Reference No:	2025/62/91605/W
Site Address:	6, Furnbrook Gardens, Kirkheaton, Huddersfield, HD5 0DY
Description:	Erection of first floor extension
Recommending Officer:	Elenya Jackson

Officer Report

Proposal: Erection of first floor extension

north elevation - side

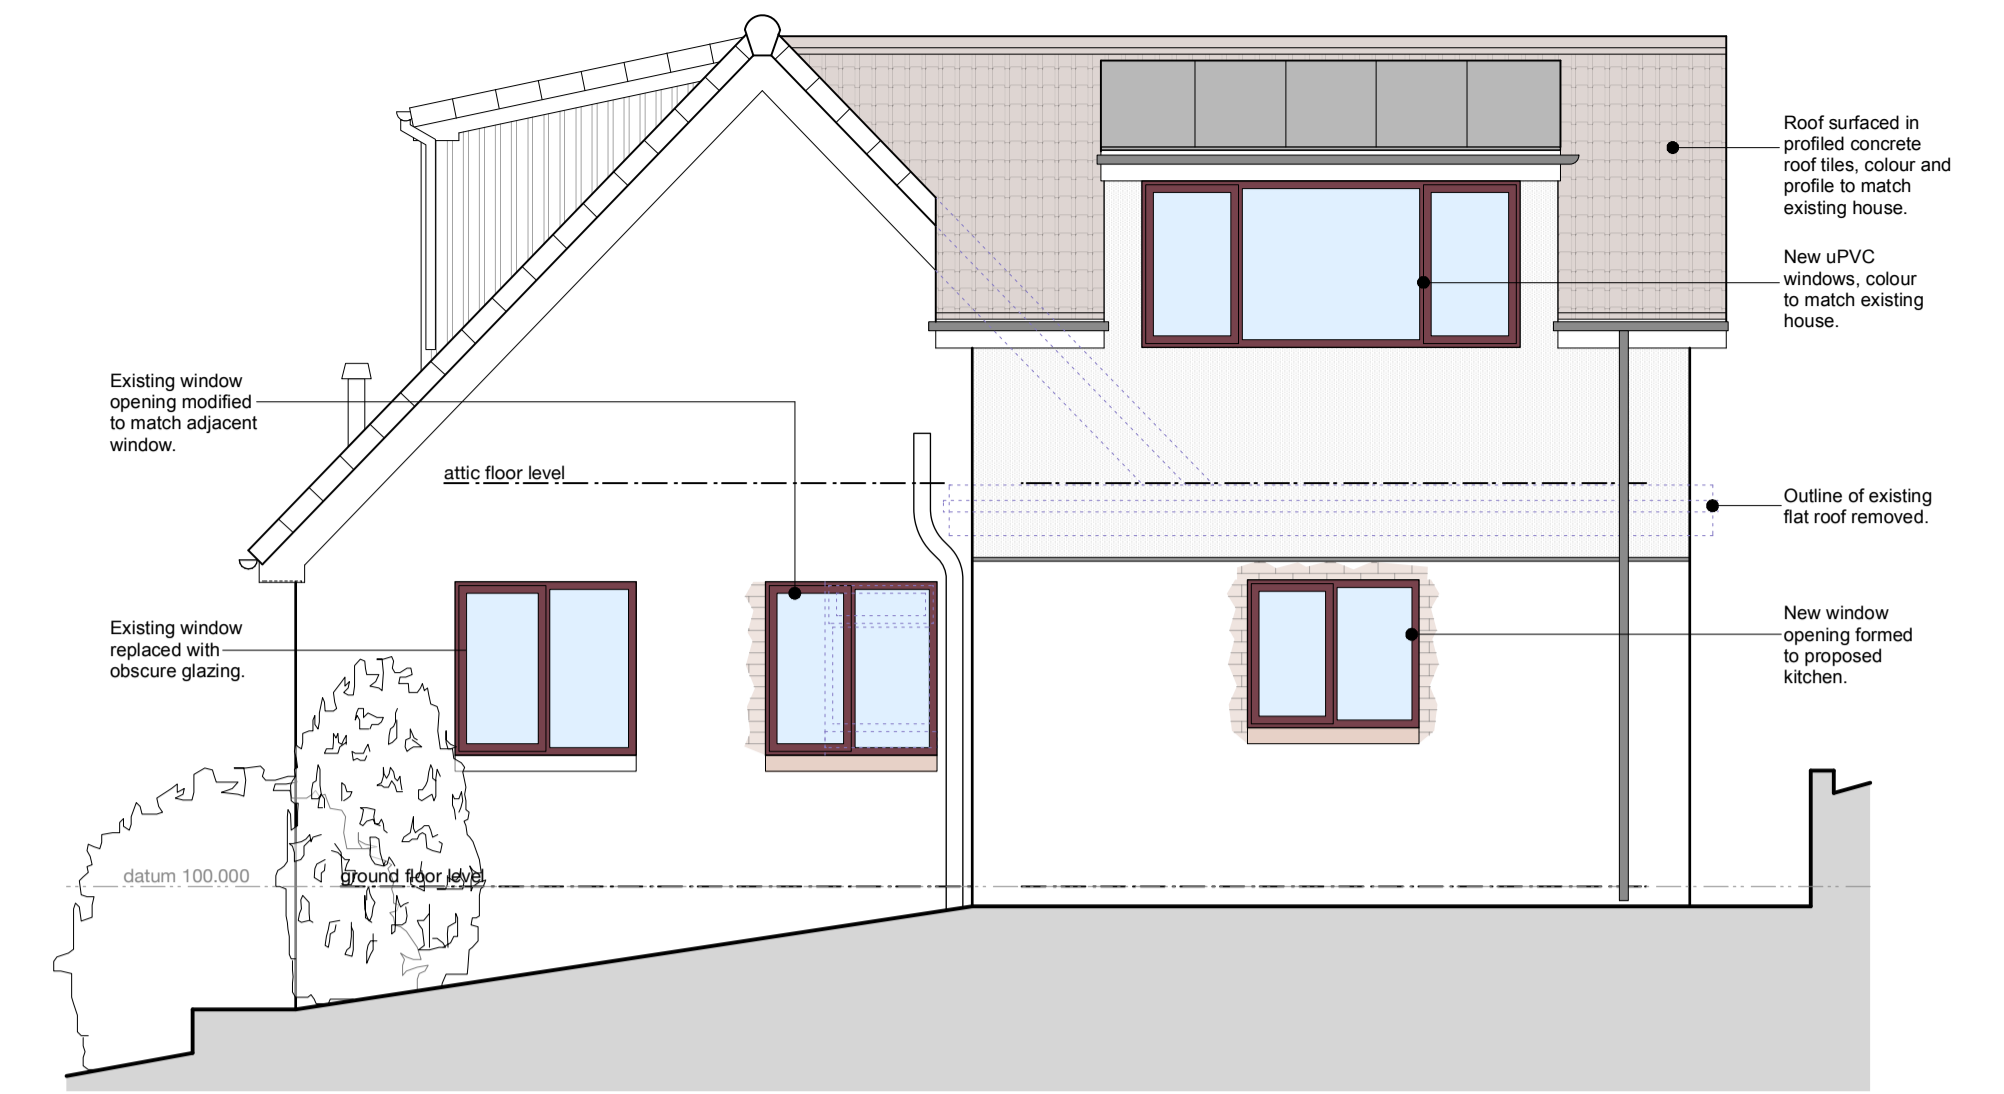
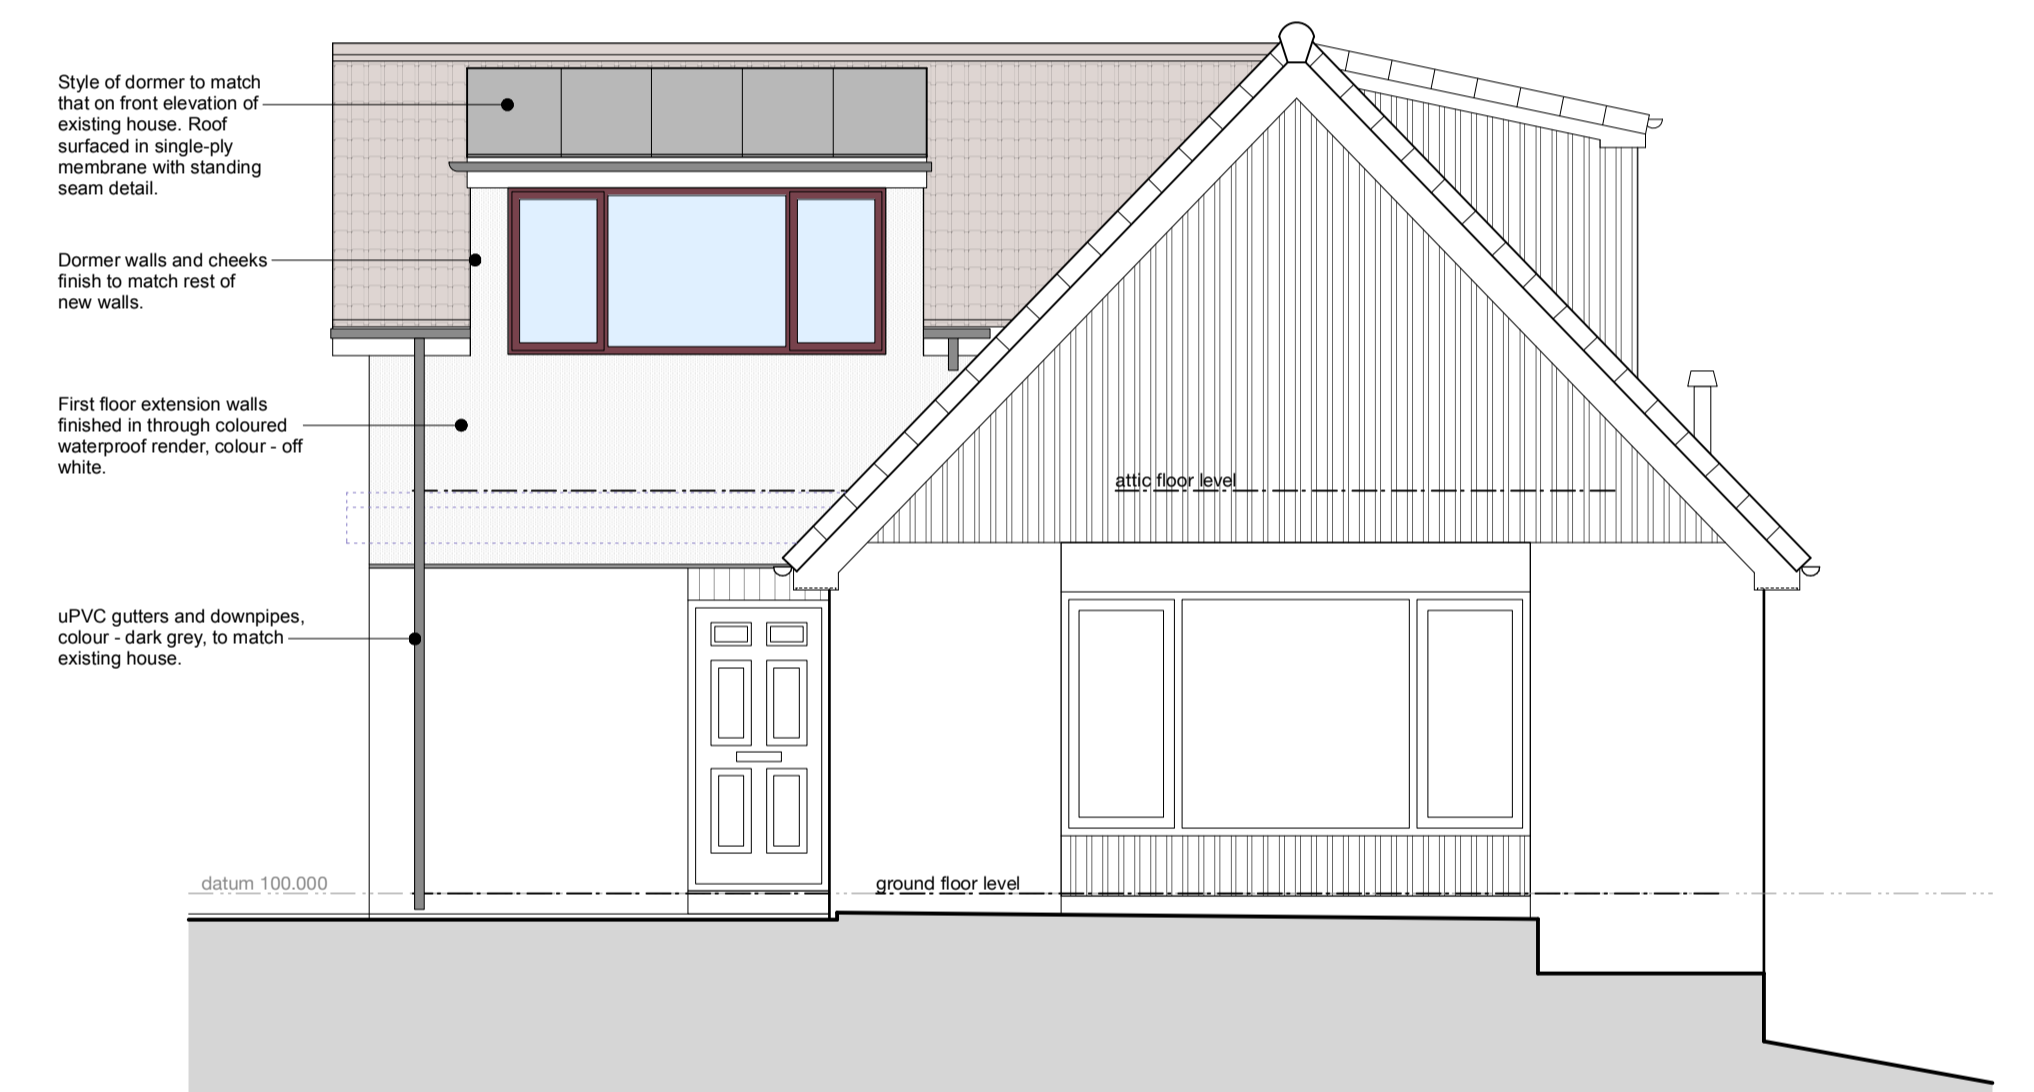
The proposed first floor side extension would project approximately 3m beyond the side elevation of the host dwelling. It is considered that the width of the extension is largely delineated by the scale of the existing ground floor projection. The proposal would have a maximum height matching the host dwelling; however, it would be set back from the principal elevation of the dwelling by 4.7m and therefore would not appear overly dominant in the street scene. It is also considered that due to the location of the proposal, there would be limited vantage points from the public realm which would further aid its integration with the street scene. Furthermore, it would appear that the neighbouring property at number 8 appears to have a similar style extension which, although approved many years prior, will act to integrate the extension into the street pattern.

Overlooking: The proposal would not add any additional side facing windows. There would be an additional window to the north of no.8; however, officers consider that this would have an offset relationship with the fenestration at no.8. Therefore, no significant issues are raised regarding overlooking.
